PLANNING CONSULTATION RESPONSE

Application No	2026/0092
Proposal	Change of use of the upper floors of the existing building from Class E to create 2x residential units (Use Class C3) with associated works including erection of external staircase to rear; installation of windows/door, and formation of car parking; and alterations to the existing ground floor commercial frontage.
Address	Andy Longden Studio, 26 - 28 Racecommon Road, Barnsley, S70 1BH
Date of Consultation Reply	18/02/26
Consultee	Highways DC

3 Proposed Site Plan
1 : 250

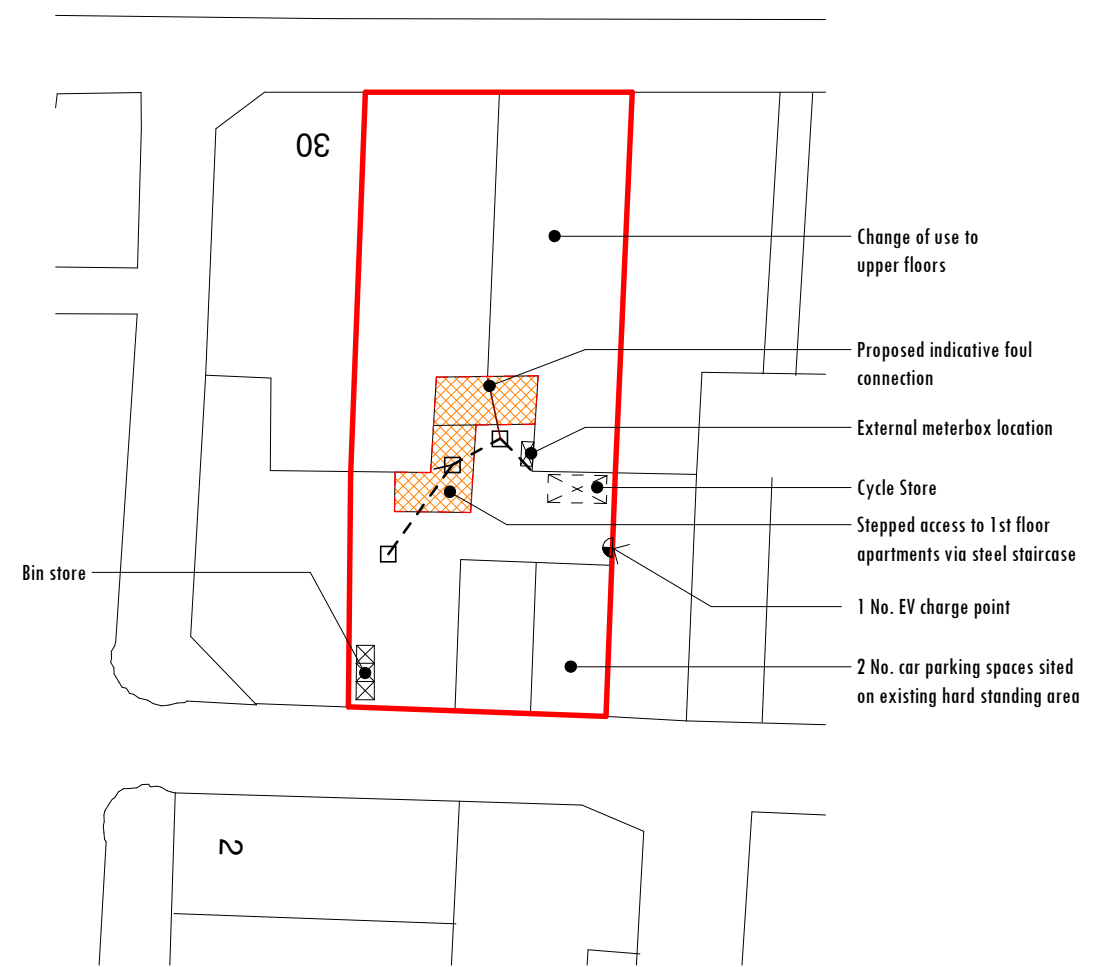
The site is within the bounds of Barnsley town centre according to the adopted local plan, so whilst parking would normally be required for all uses rather than just reattributing the two spaces for the flats, the highly sustainable location of the site means that the present parking arrangements continue to be acceptable in scale, but HDC officers would ask that they are brought up to a better standard of surfacing as part of the external works.

The parking facilities as indicated on the submitted plan shall be surfaced in a solid bound permeable material (i.e. not loose chippings) and adequate measures shall be so designed into the proposed access to avoid the discharge of surface water from the site on to the highway.

No works shall commence on site until a scheme for the parking of bicycles complying with LTN 1/20 Cycle Infrastructure Design has been submitted to and approved in writing by the Local Planning Authority. The scheme shall be fully implemented before the development is first occupied (or brought into use) and thereafter retained for this purpose.
